From: William Clark
To: Helen Donaldson
CC: David Margolis-Pineo; Jennifer Thompson
Date: 6/1/2015 4:11 PM
Subject: Re: Fwd: Bishop Street Draft Plat plan
Attachments: Bishop St No 72 Subdivision Plat Plan 5 22 2015 Survey Review 6 01 2015.PDF; Bishop St No 72 Boundary and Topo Survey Rev 1 20 2015 Survey Review 5 12 2015.PDF

This is a draft subdivision plat for a 30-unit Avesta project, all apartments, out on Bishop Street. Could you take a look and let me know your comments when you have a chance?

BOUNDARY & TOPOGRAPHIC SURVEY
AT
72 BISHOP STREET, PORTLAND, MAINE
MADE FOR
AVESTA HOUSING
307 CUMBERLAND AVENUE, PORTLAND, MAINE

Title:
SUBDIVISION PLAT
PLAN

**BOUNDARY & TOPOGRAPHIC SURVEY**  
 AT  
 72 BISHOP STREET, PORTLAND, MAINE  
 MADE FOR  
**AVESTA HOUSING**  
 307 CUMBERLAND AVENUE, PORTLAND, MAINE

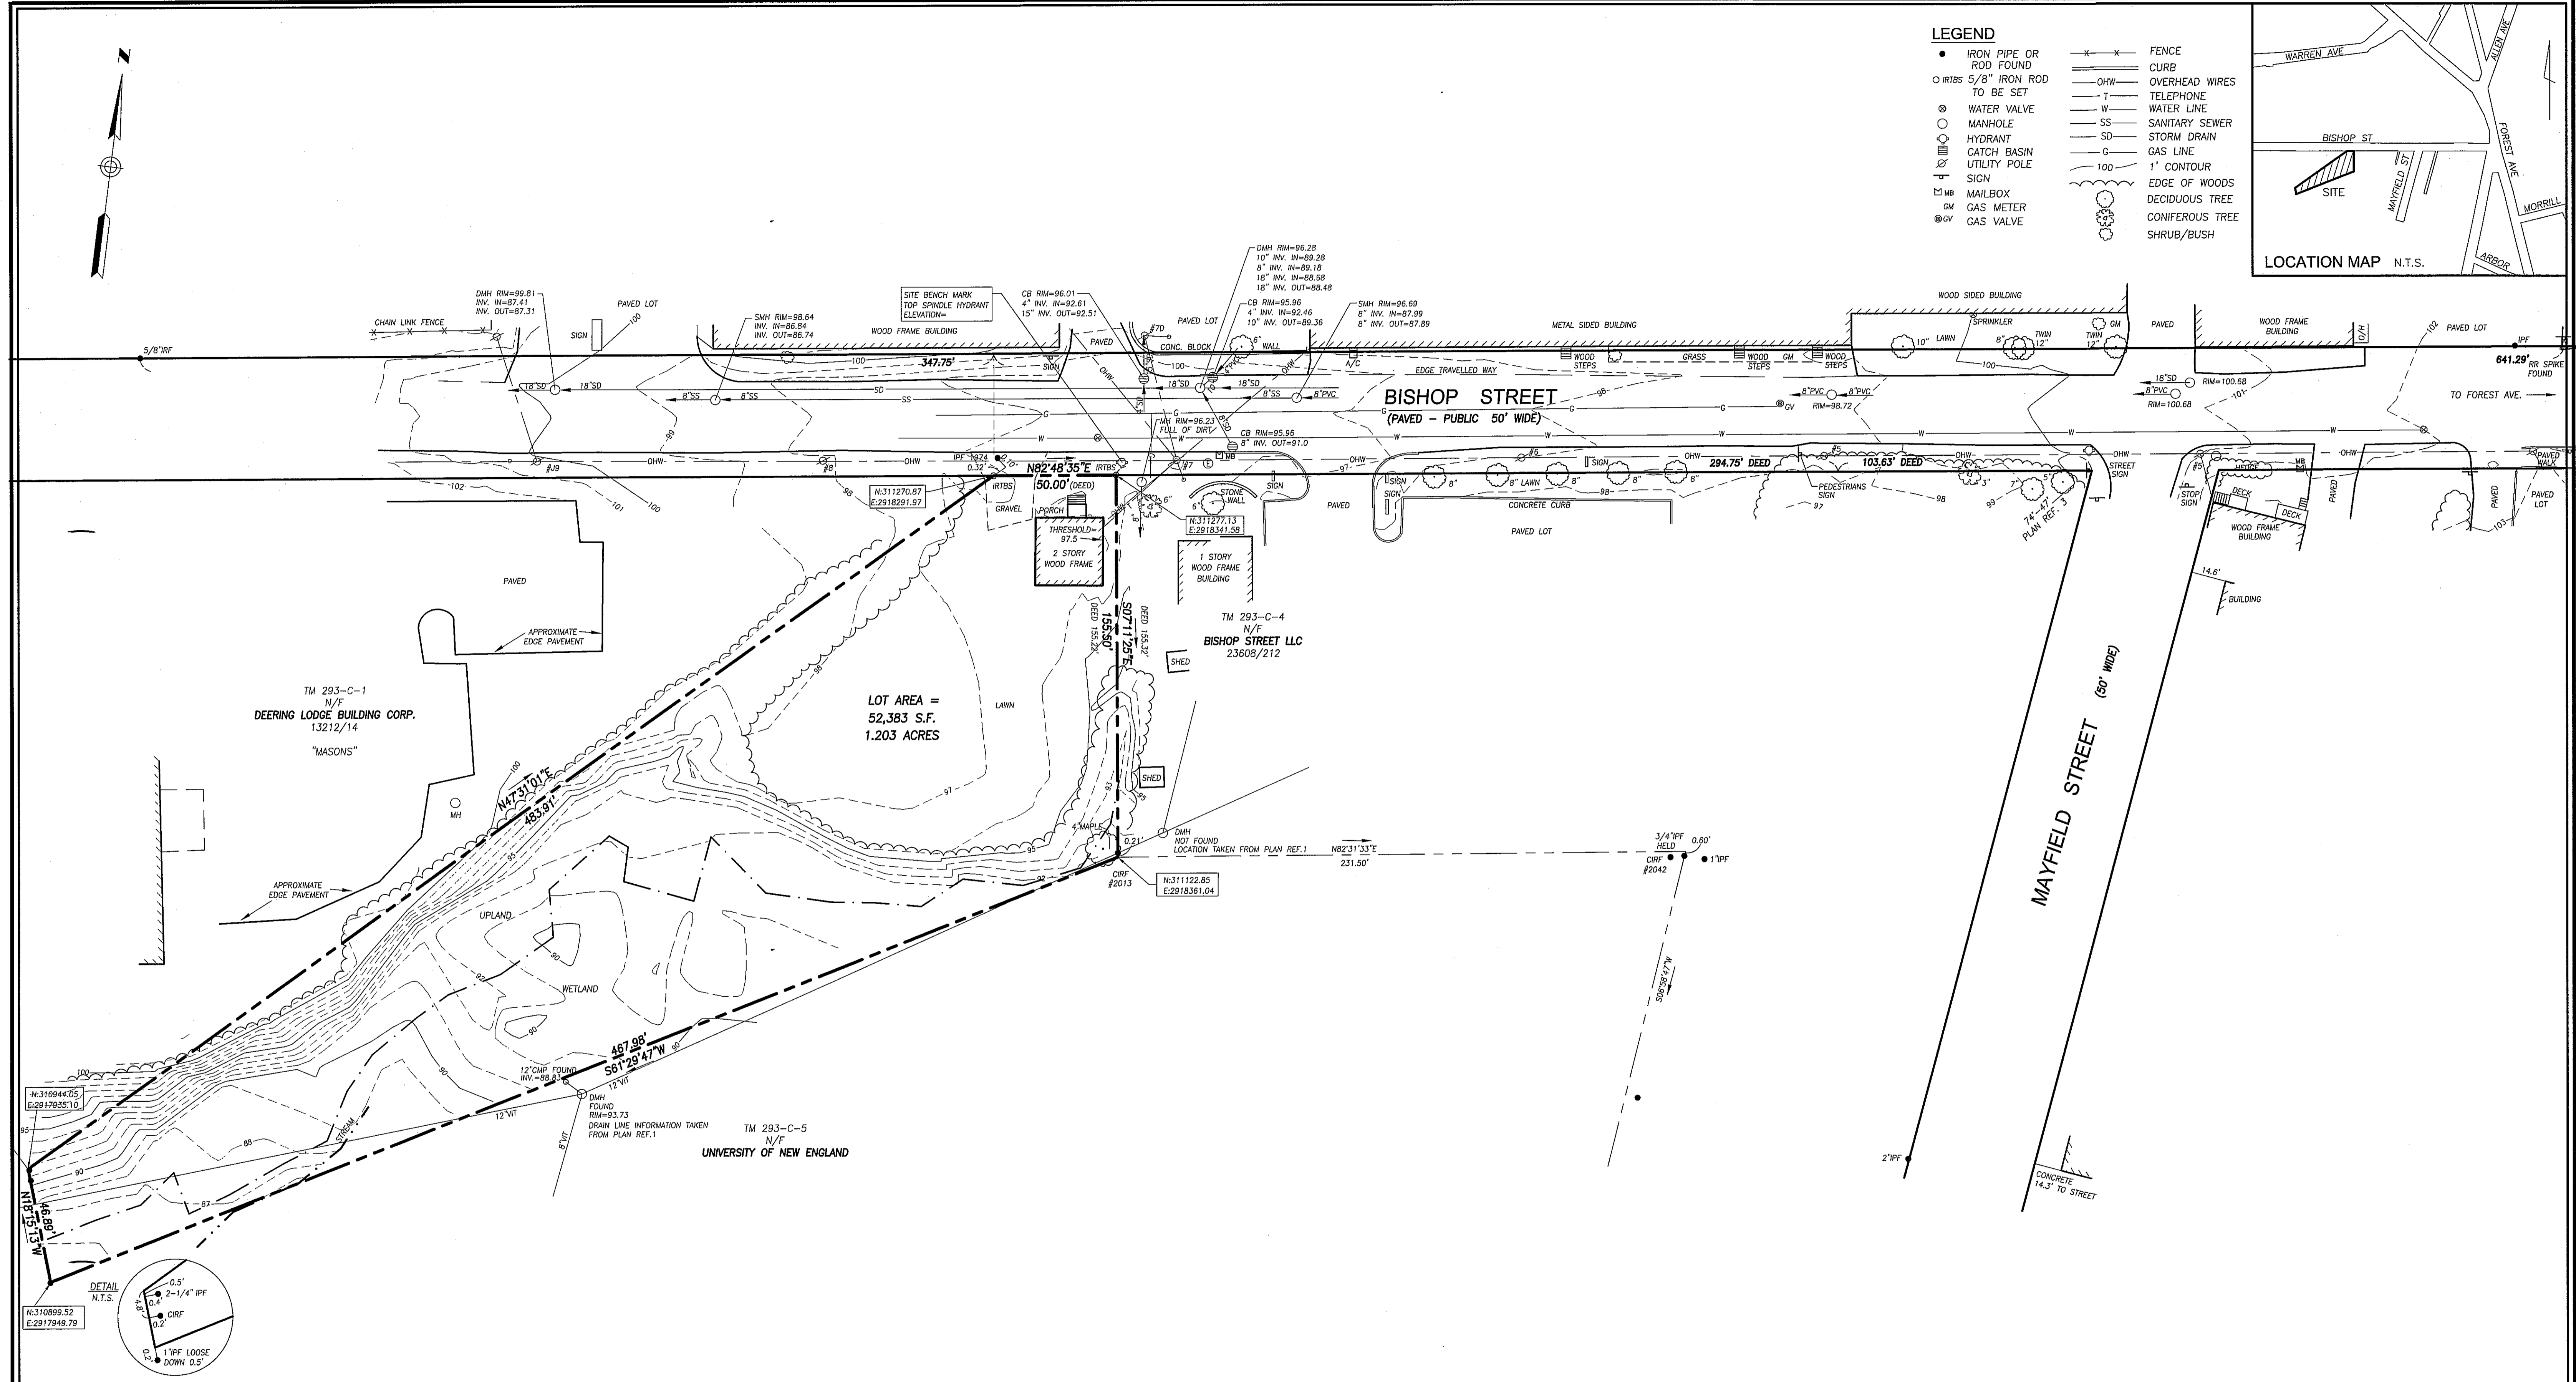
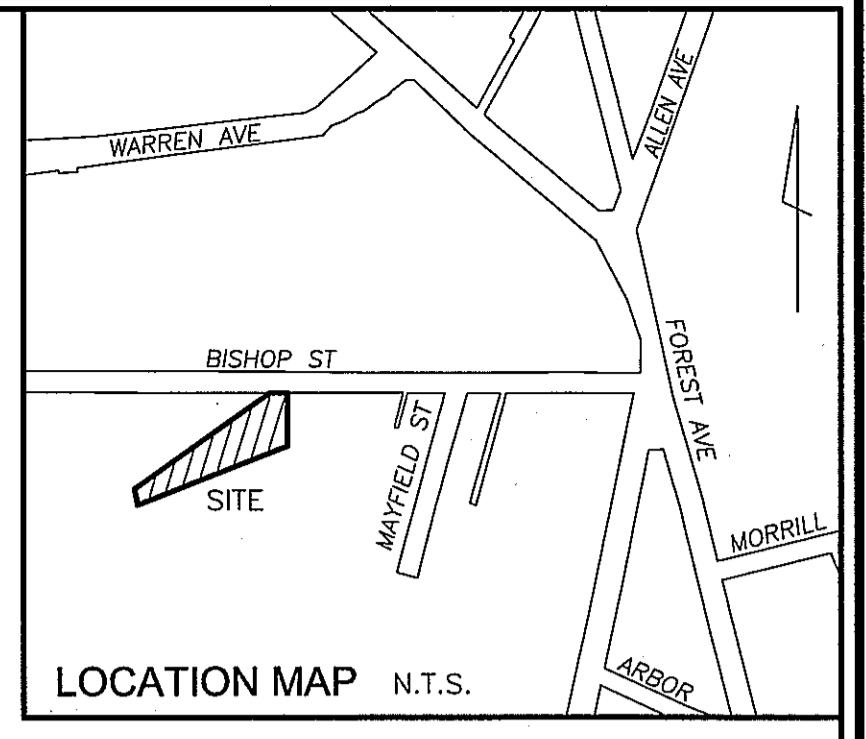
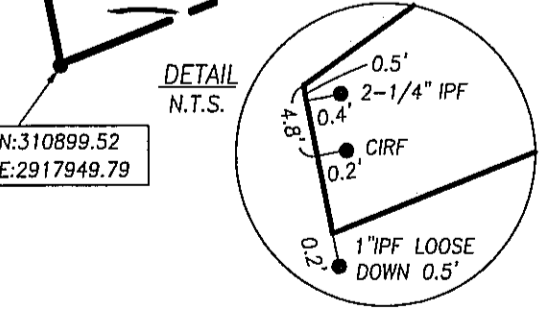
I met with Bob Metcalf of Mitchell Associates last week and went over the Boundary and Topographic Survey plan (attached).

He agreed to show the proposed 30 foot storm drain easement on the plans. That has not been corrected.

Title:
SUBDIVISION PLAT PLAN

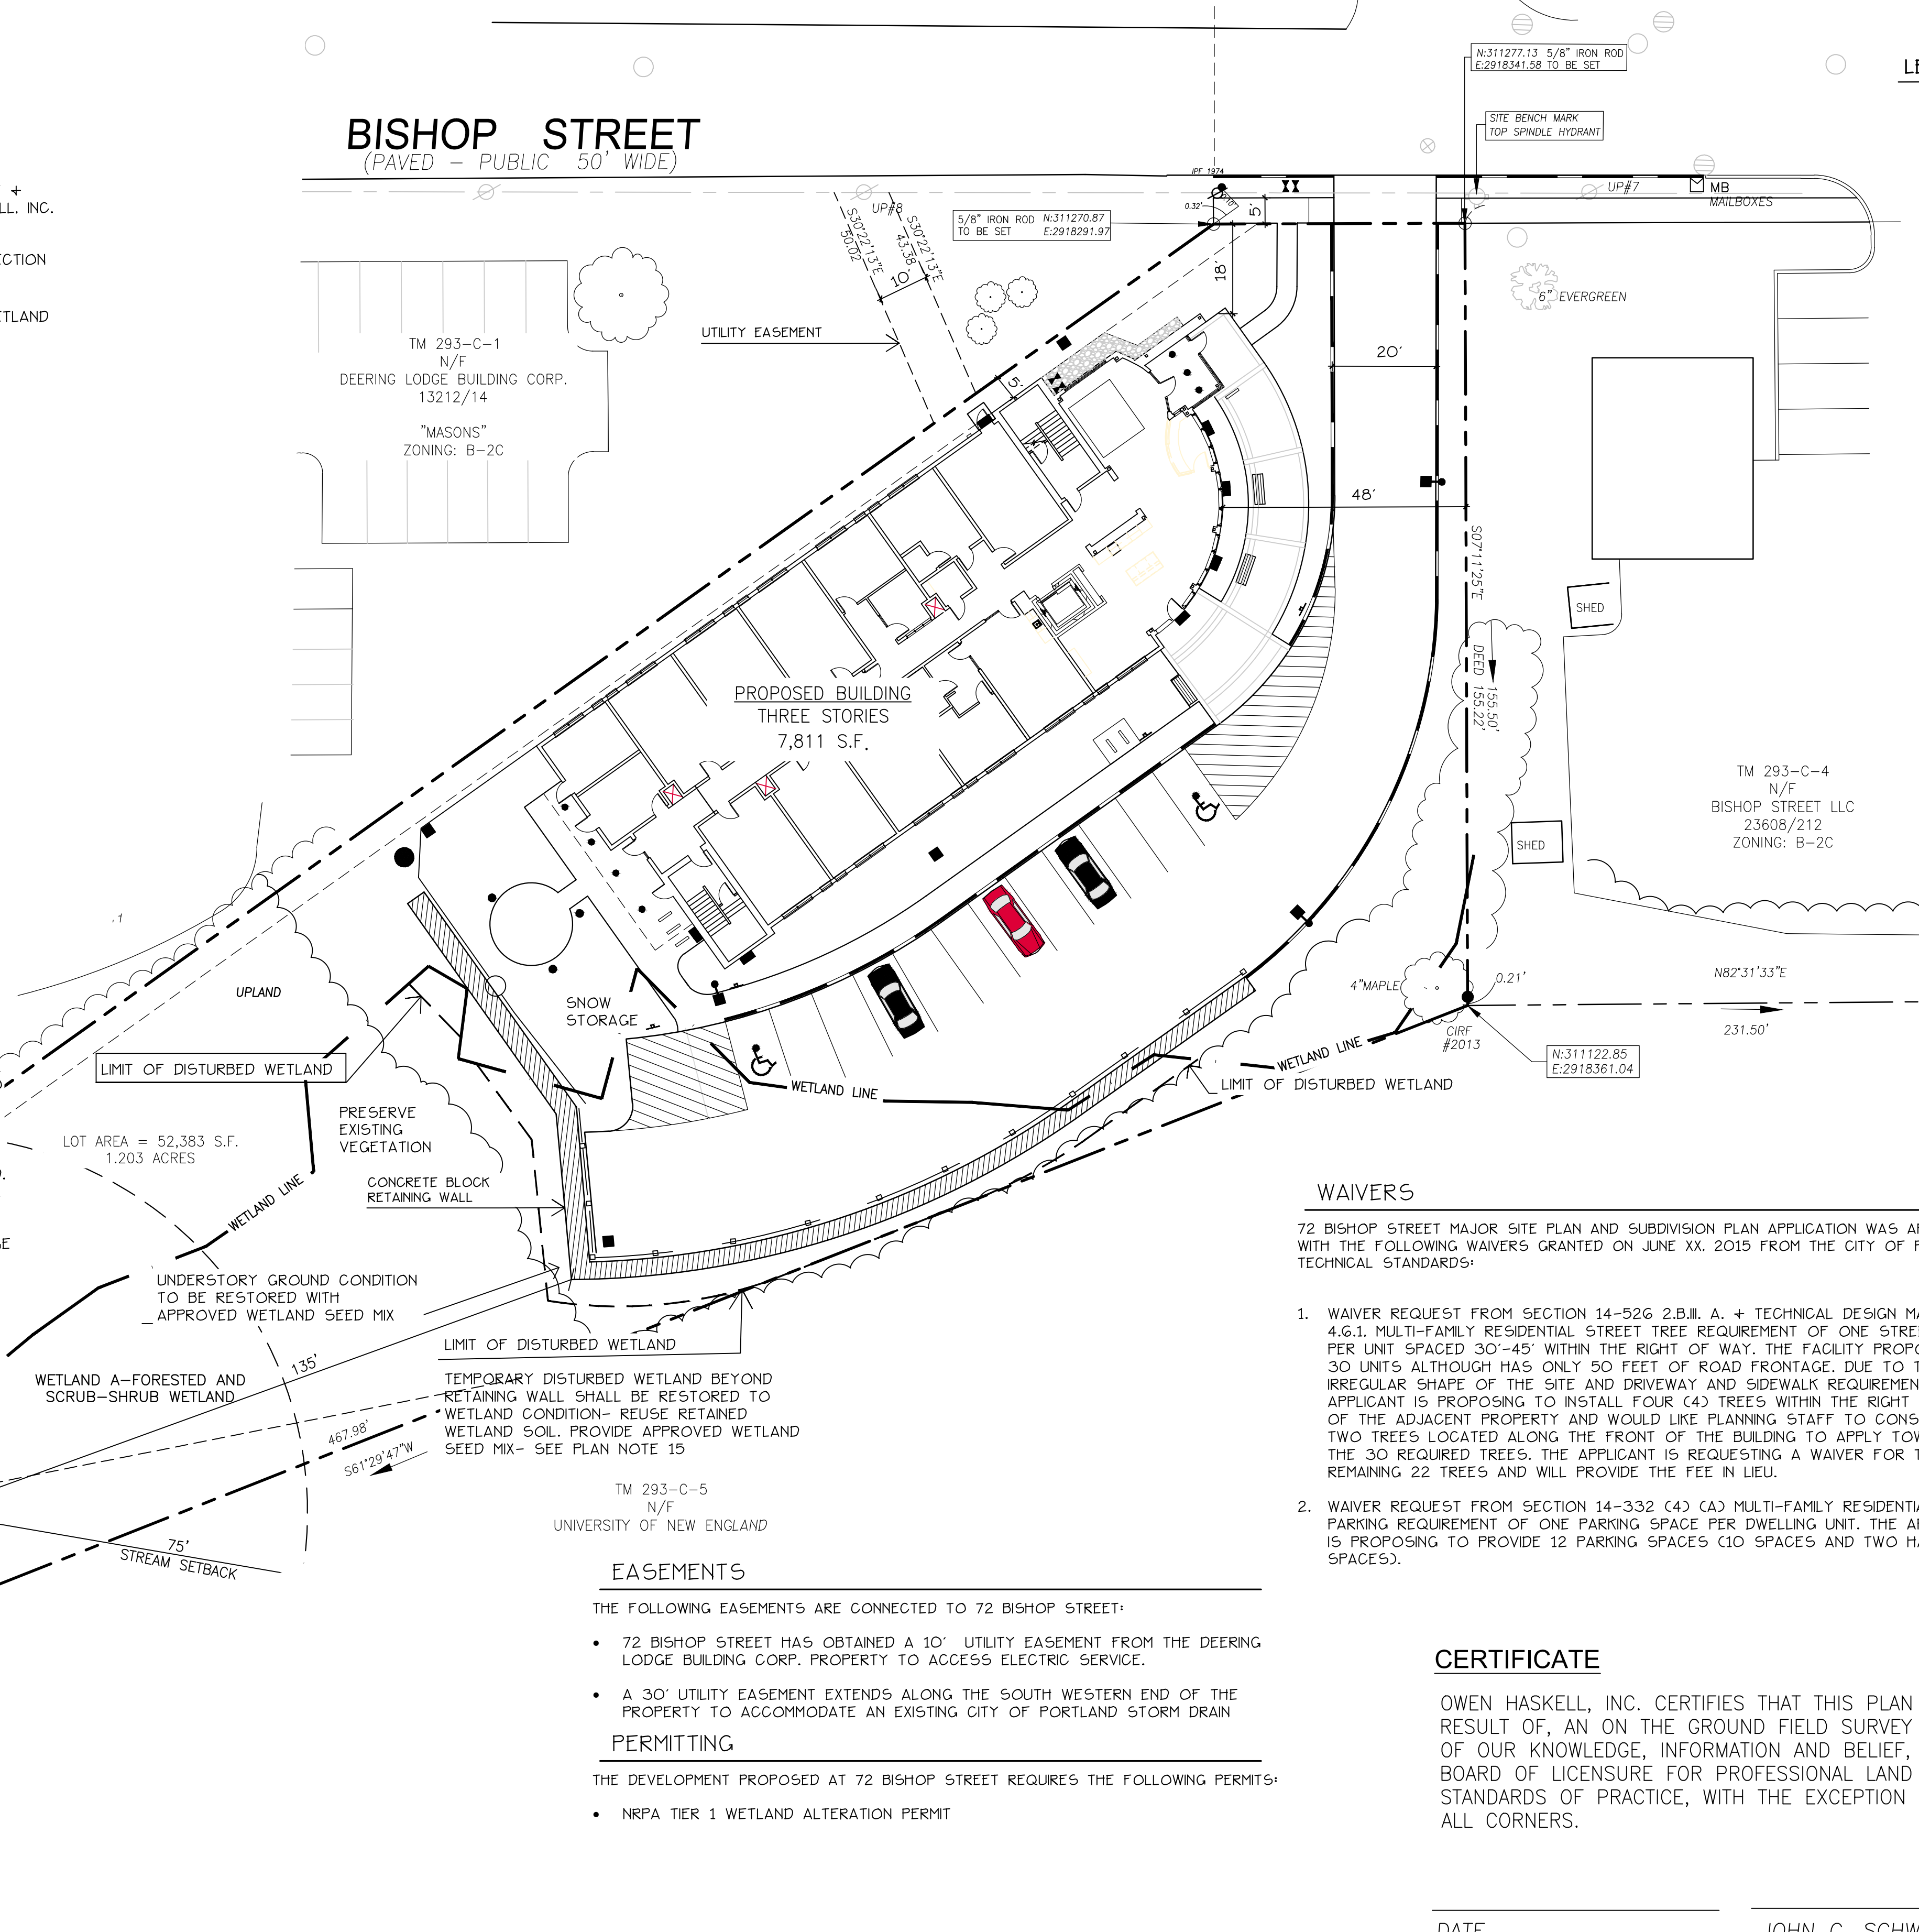
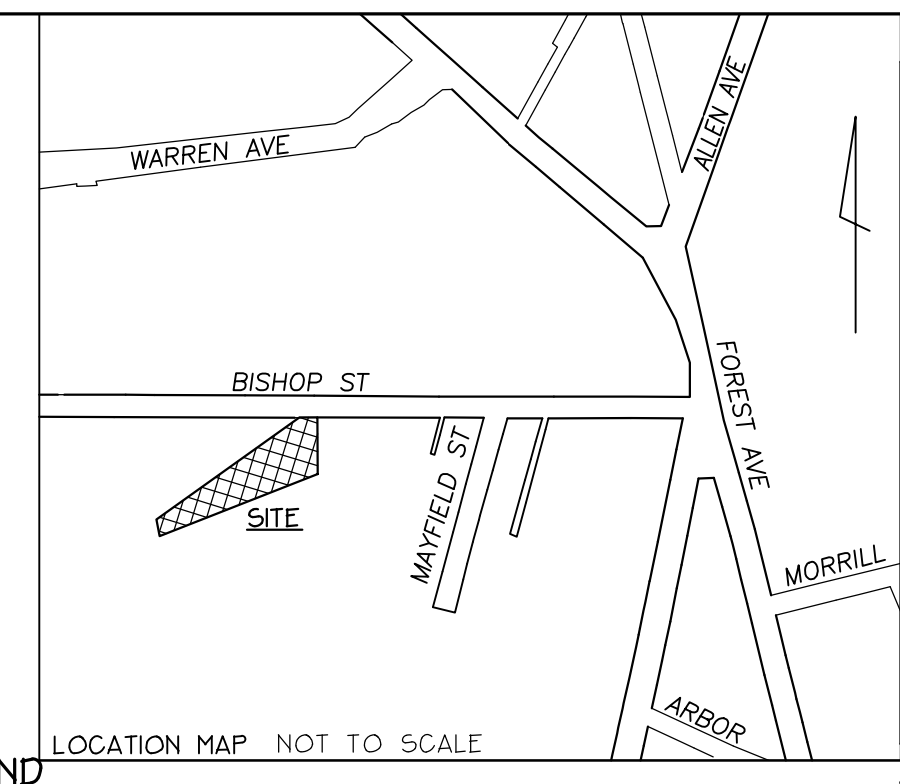
In addition, the same elevation datum problem exists on the Subdivision Plat Plan dated 5 22 2015 which you sent me this morning. They state they used NAVD88 which is not the official City datum. Existing Grades/Topo, Proposed grades, and structures need to be corrected to the Official City of Portland Datum prior to approval.

- BEARINGS ARE GRID NORTH AND ELEVATIONS ARE NAVD83 AS BASED ON STATIC GPS COLLECTION AND OPUS CORRECTION. *NOT CORRECT CITY DATUM IS NGVD29. SITE TOP & PROPOSED GRADES & STRUCTURES NEED TO BE CORRECTED TO NGVD29.*
